Pymble Ladies College - Grey House Precinct (SSD-17424905)

Response to Submissions

Attachment A–Key Issues

3 SHADOW DIAGRAM PROPOSED June 21 - 2PM
1 : 1000

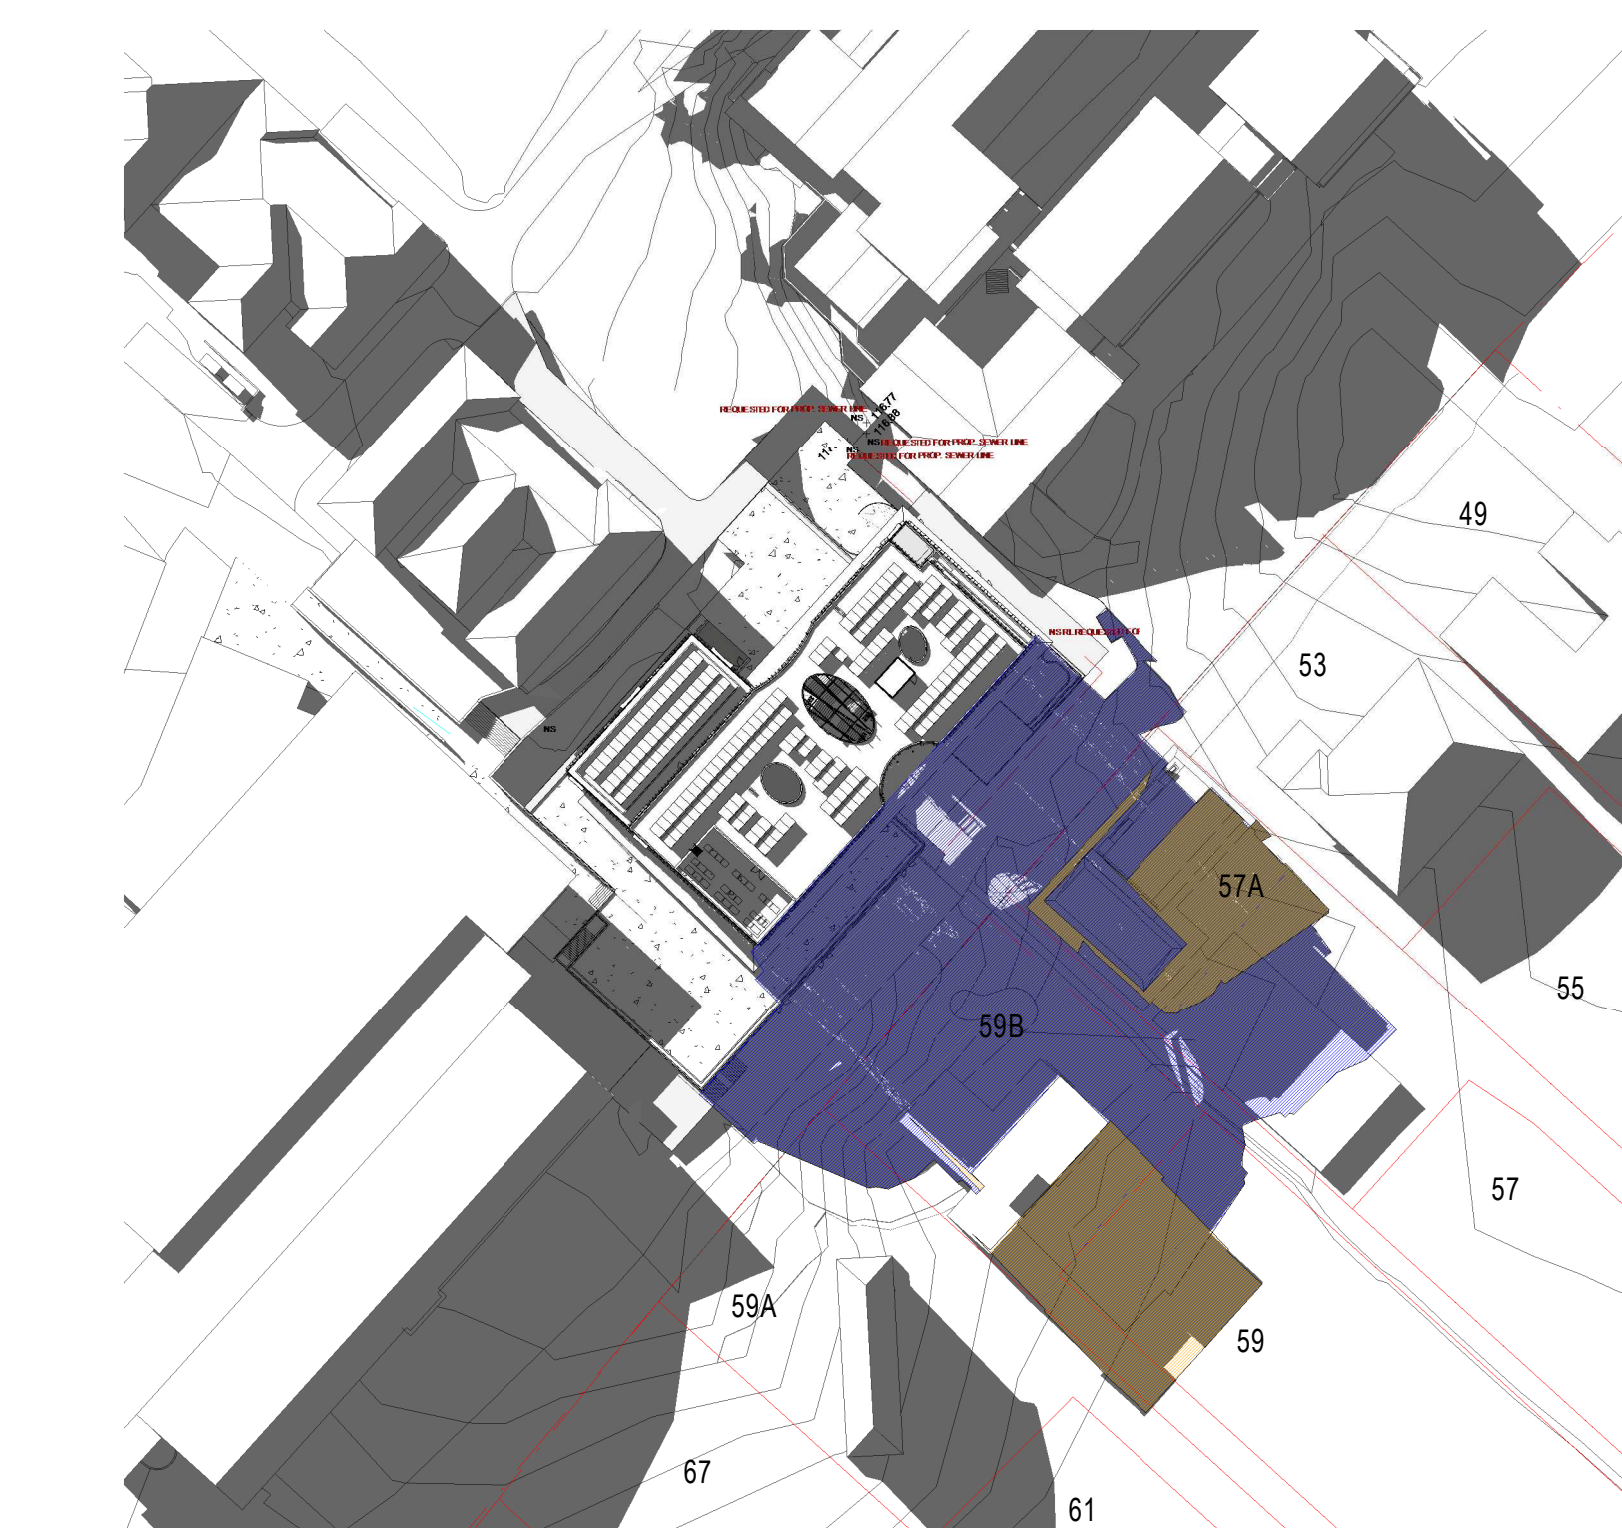
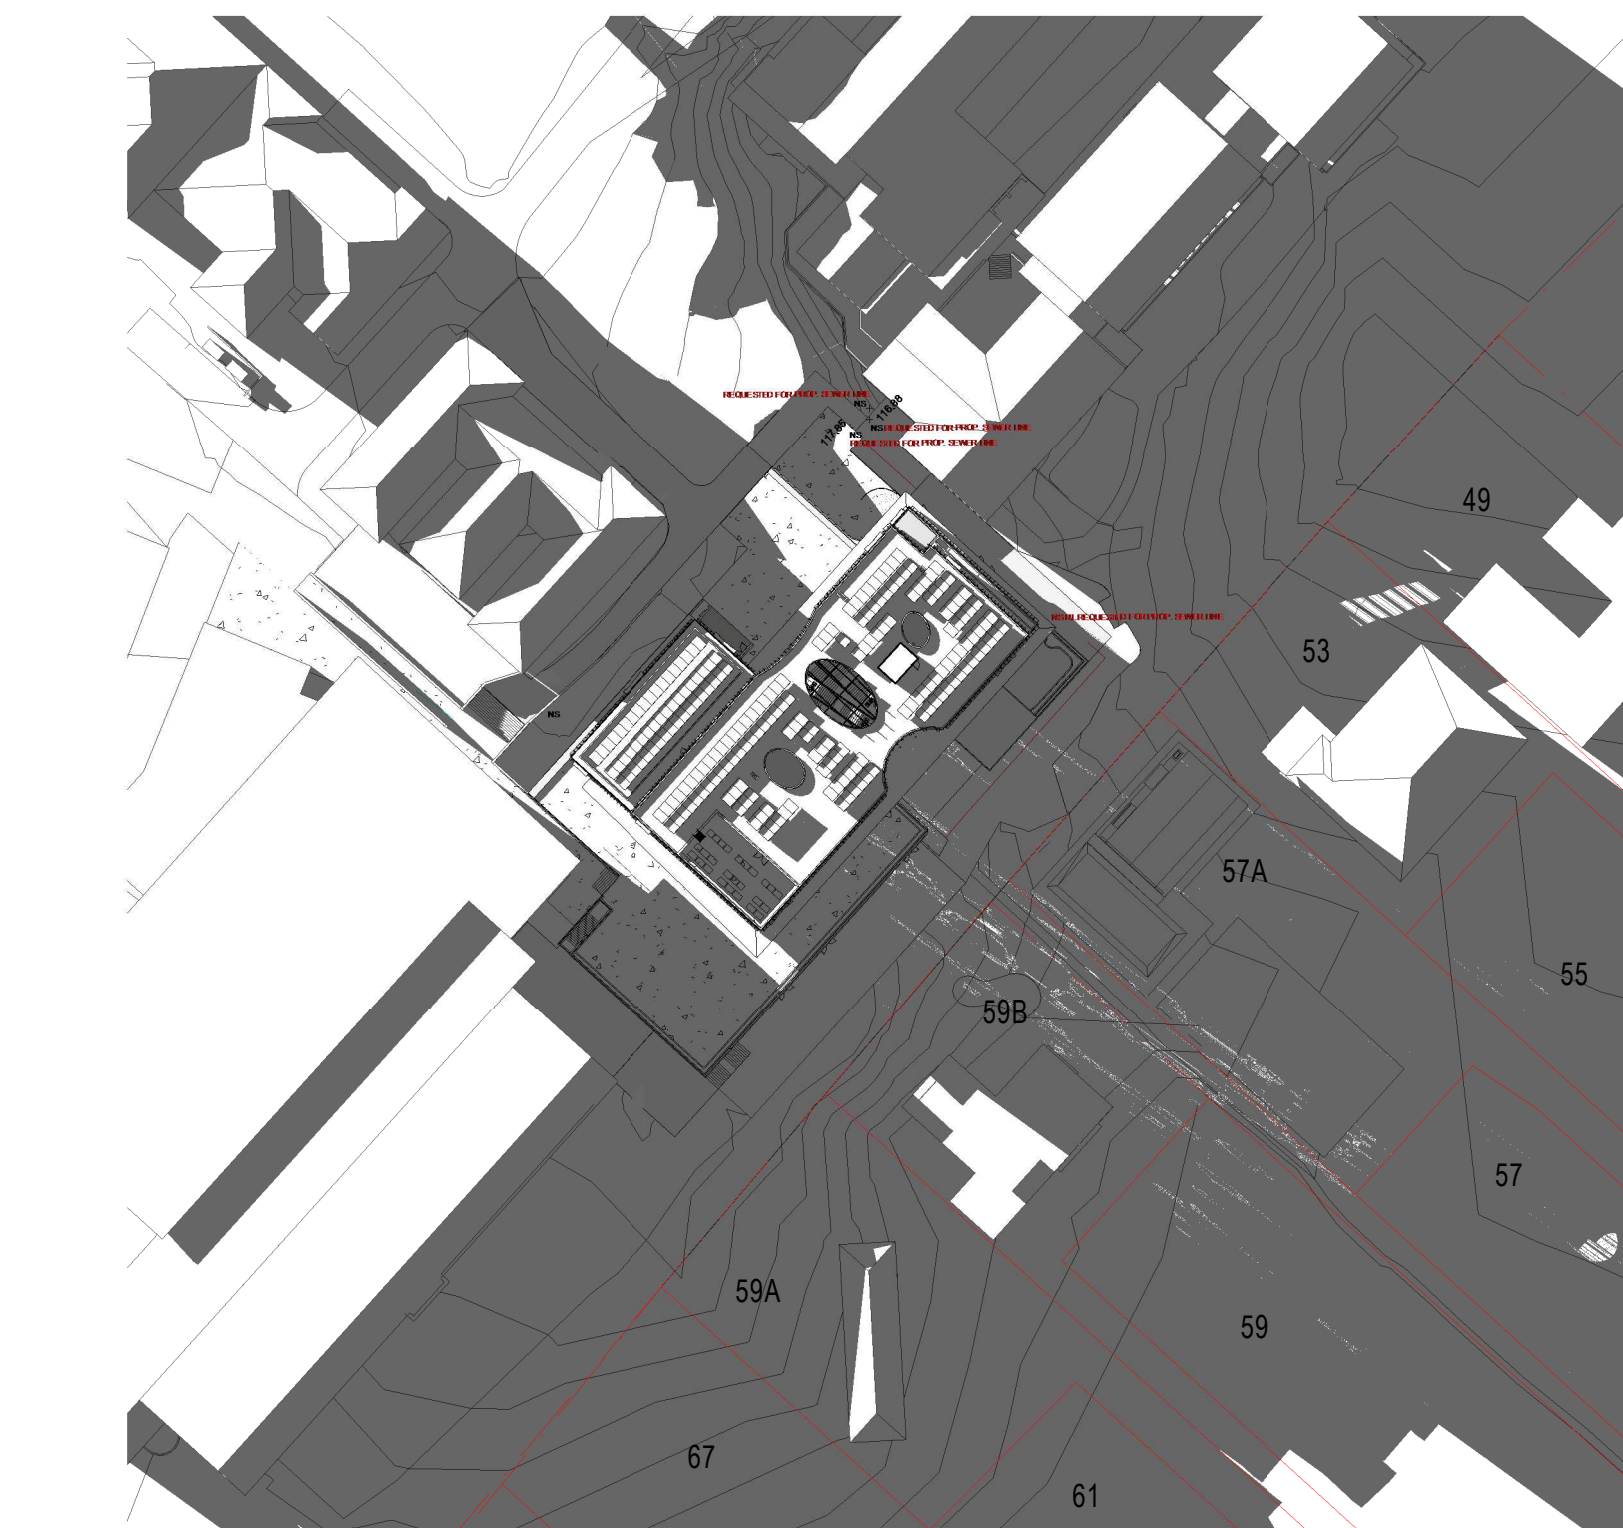
2. According to the Ku-ring-gai Development Control Plan, a building should be sited to maintain solar access to north facing windows and rear yards of adjoining properties of at least four hours between 9am and 3pm on 21st June. The proposed development does not comply with this requirement. Please address this issue and demonstrate how the development would maintain an appropriate level of solar access to the impacted properties (to its south) during winter solstice.

DEVELOPMENT OF FACADE - SHADING

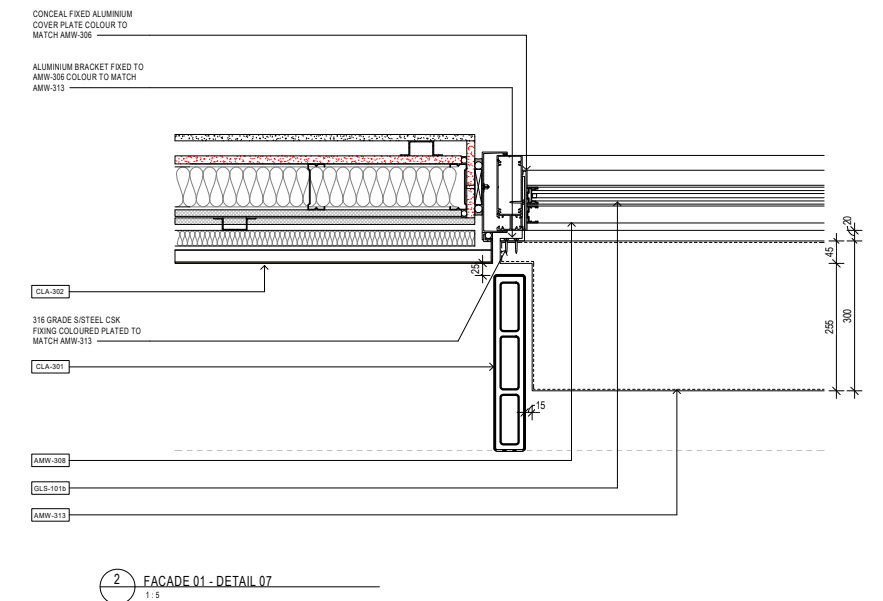
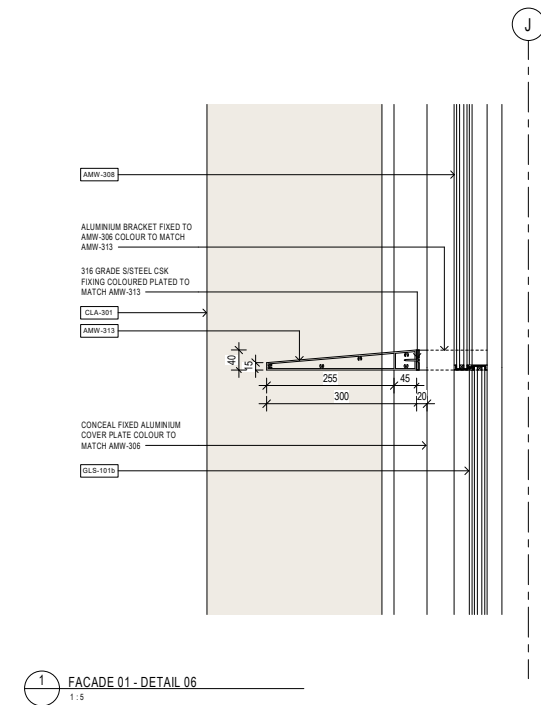
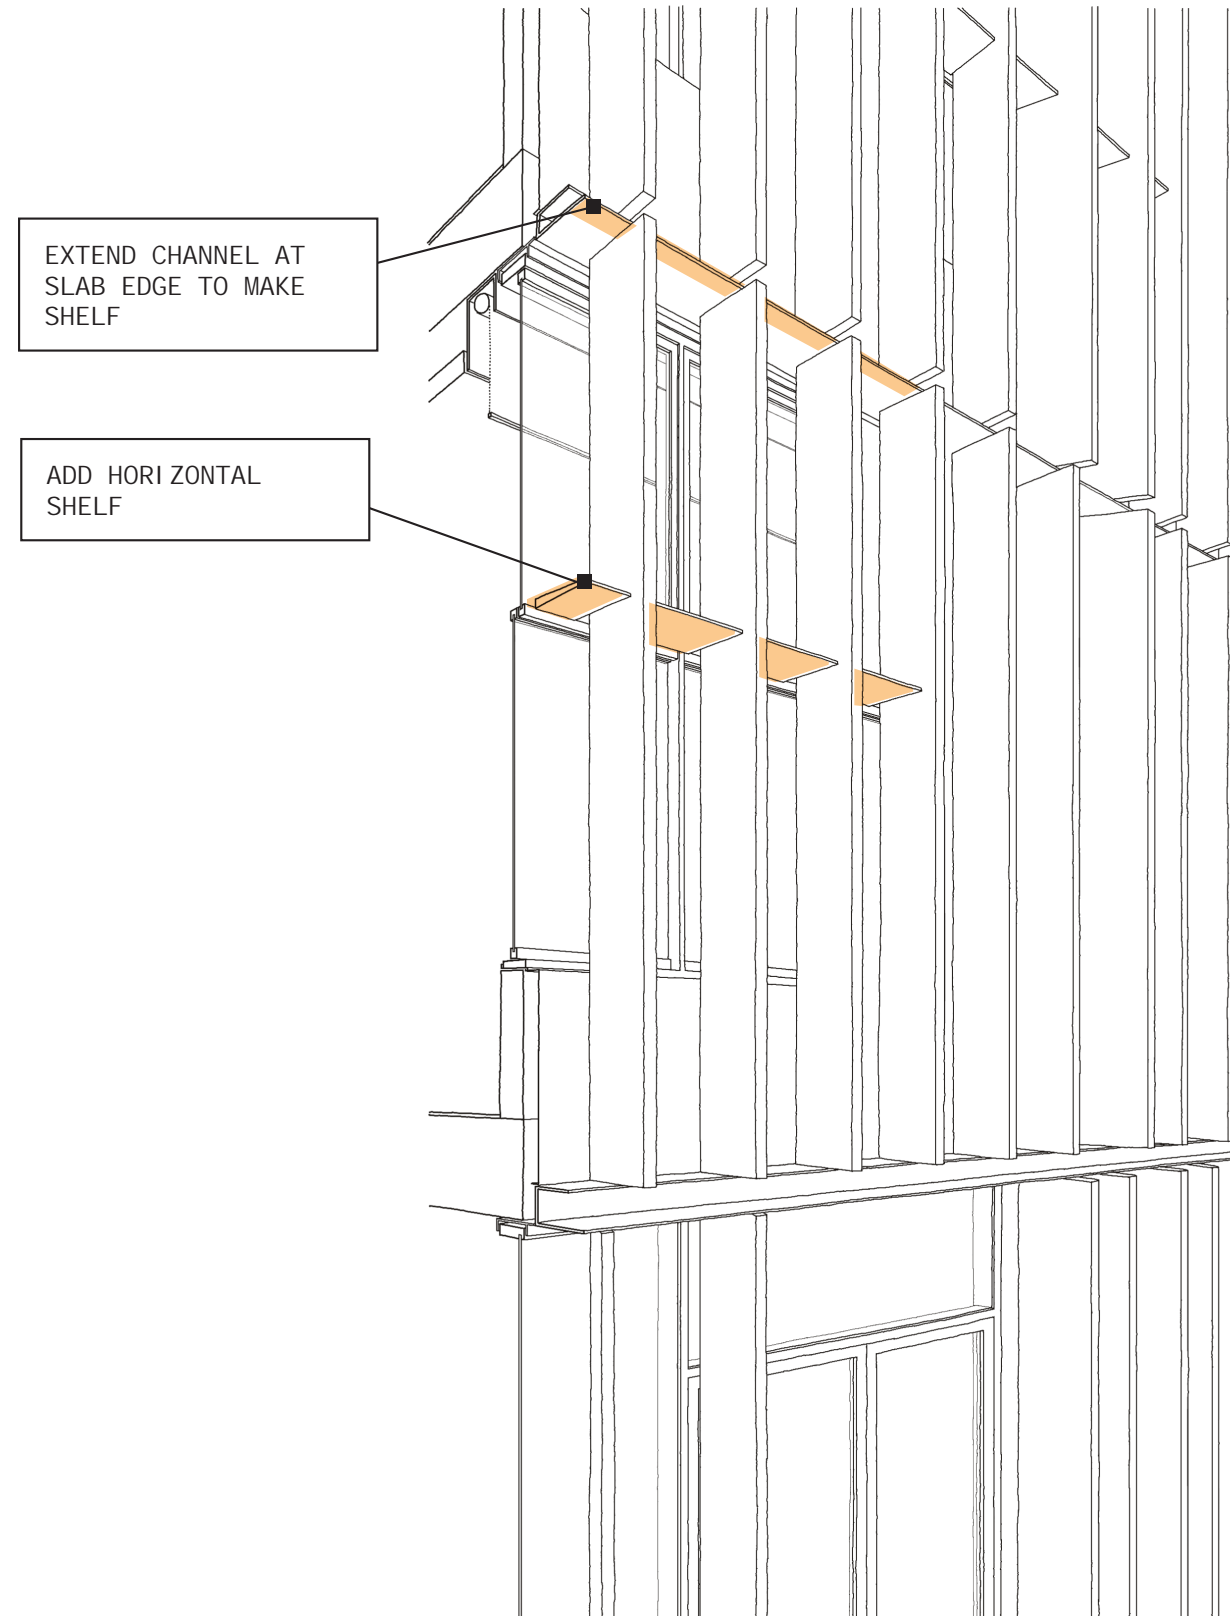
- The proposed glazing treatment should be complimented with more horizontal shading strategies to improve daylight and enable access to natural ventilation.
